Subject: LU/338/21/PL - Further Engineers Comments

Further Engineers Comments Regarding Surface Water Drainage

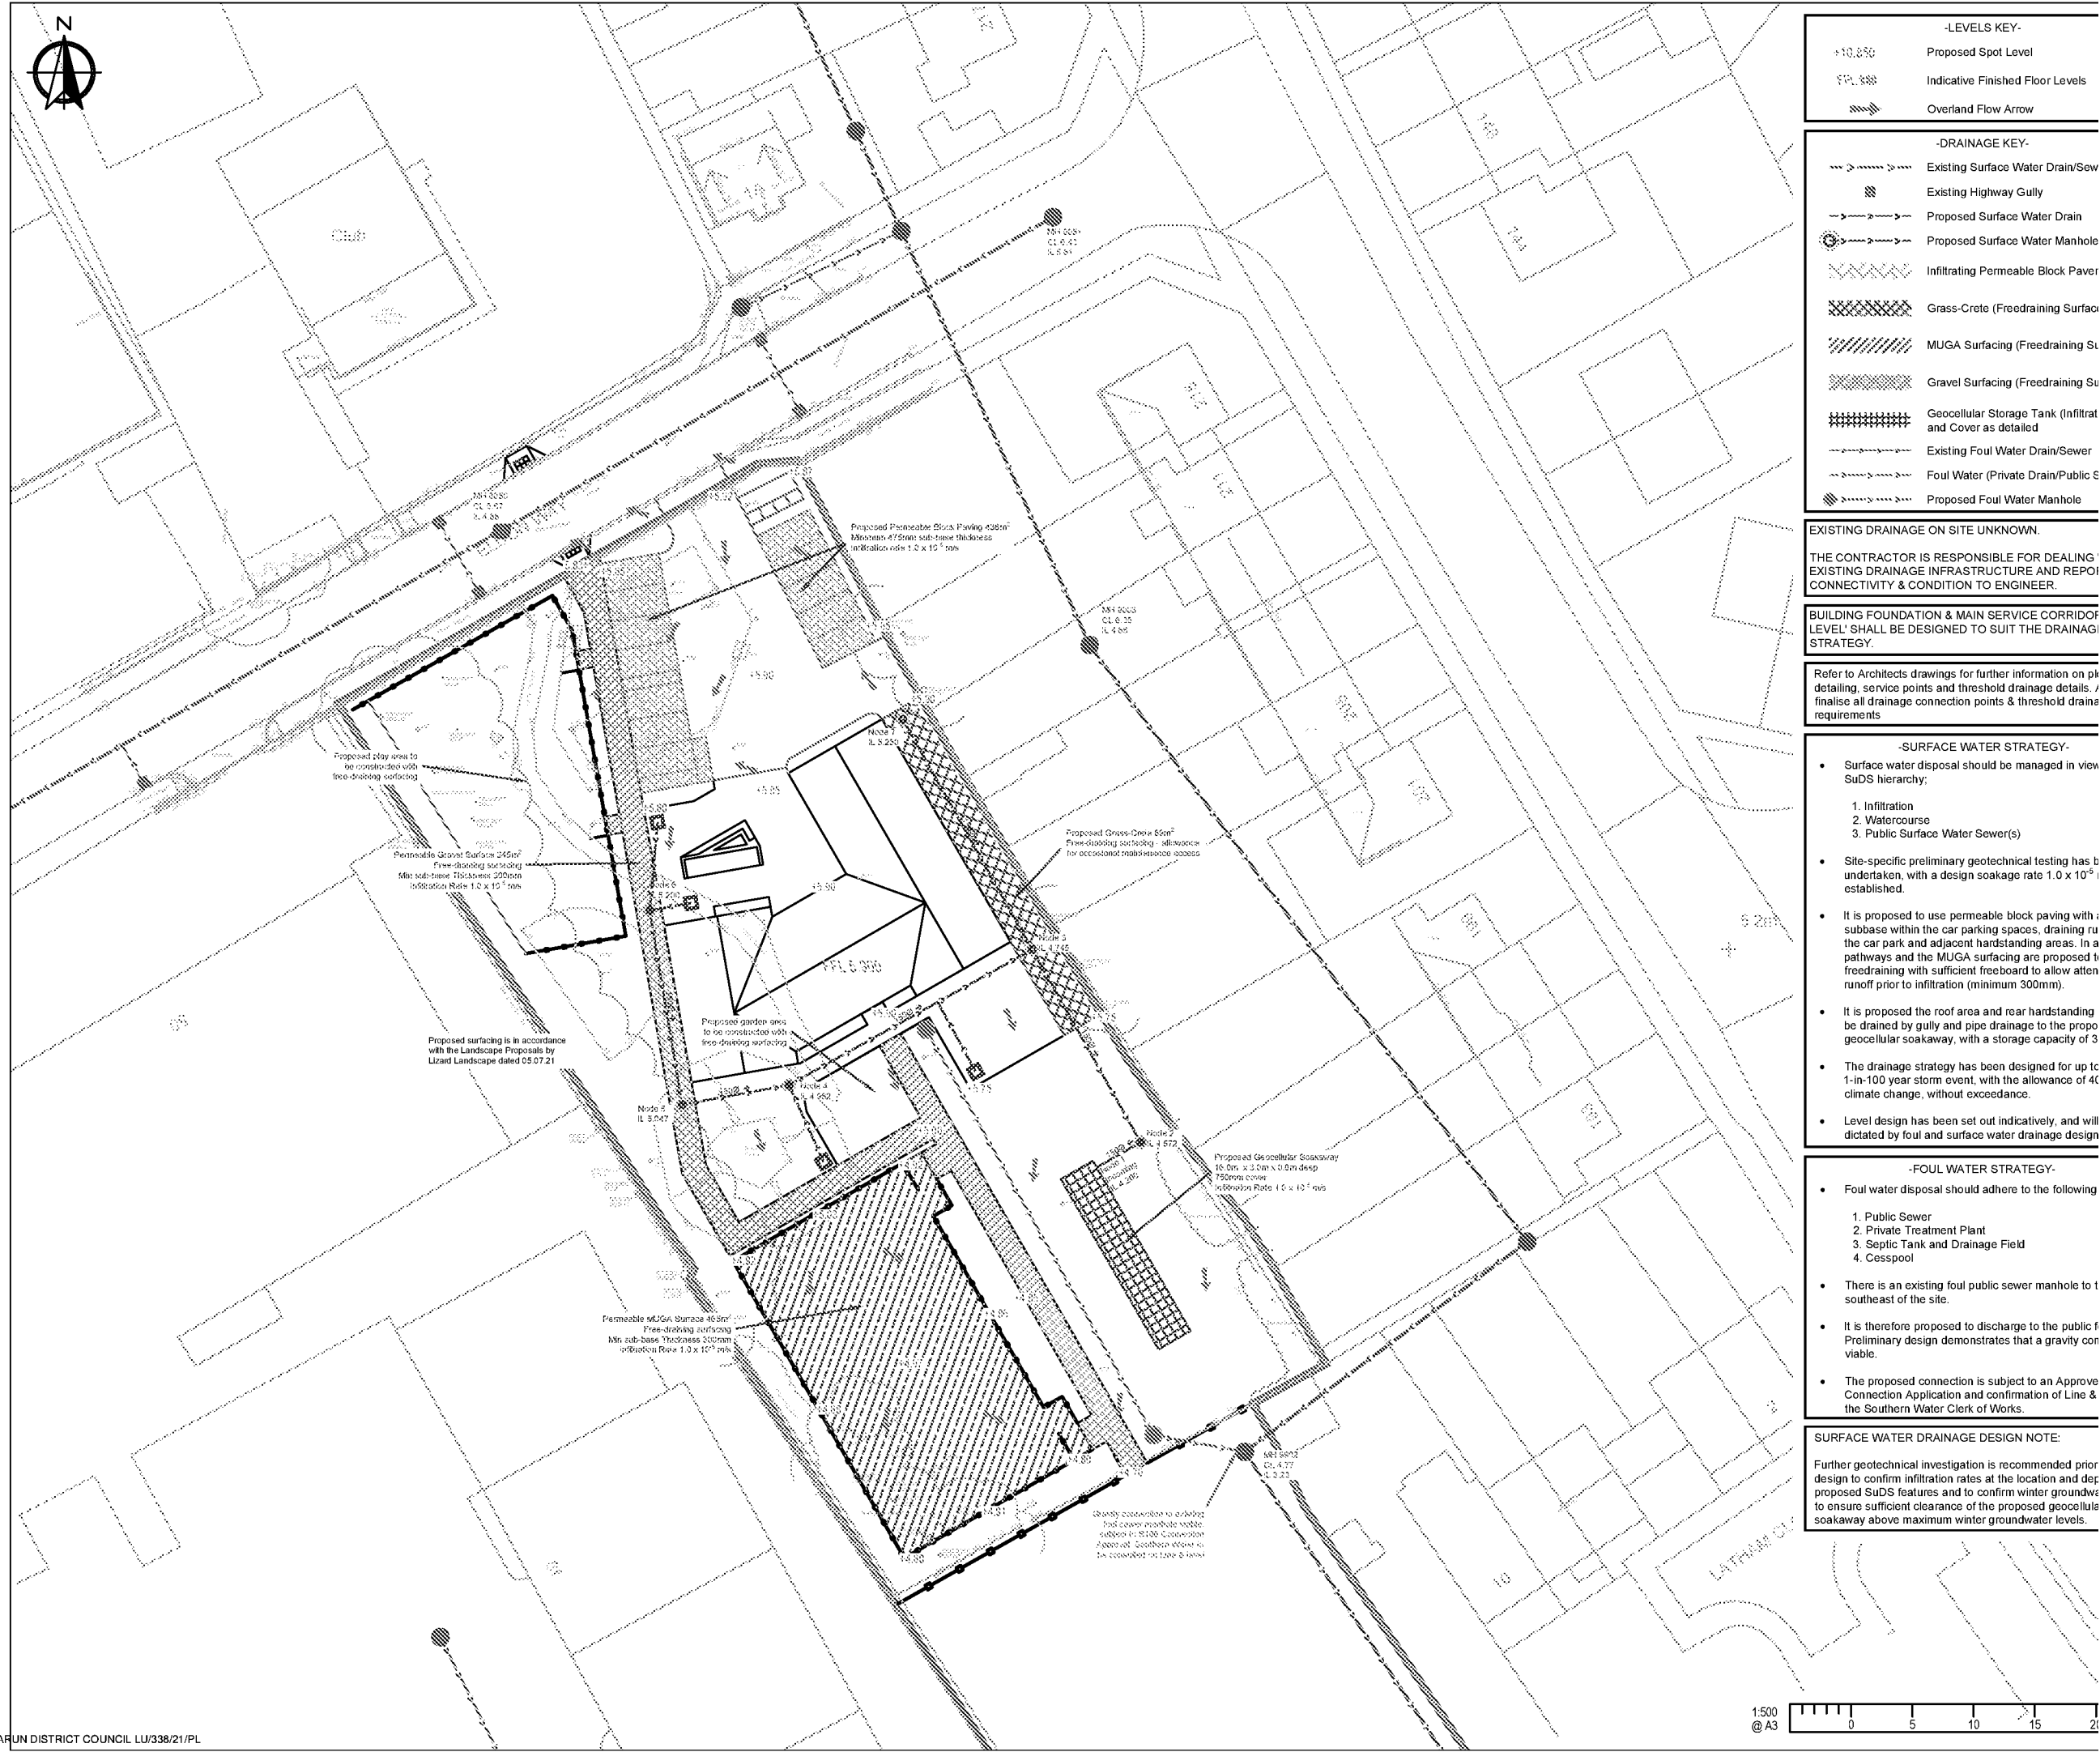
- b. CV Values (both winter and summer) should be set to 1 for all events and all drainage structures.
2. It is not clear exactly how the MUGA is to be drained. The general arrangement and drainage layout EX.01 rev C1 shows a soakaway S2 but the calculations appear to model a blanket permeable subbase. There is also no construction detail for the drainage for the MUGA. Please clarify.

- a. Please give the invert (base) level and cover level of the soakaway(s).
 - b. List cover types for inspection chamber covers. Note 10 says these should be adjusted to suit final surface levels but gives no indication of which covers should be used in which circumstances.

- c. Manhole S1 is listed in the schedule as a catch pit, please list the sump depth.
4. Please provide the following construction detail drawings:
 - a. Permeable paving.
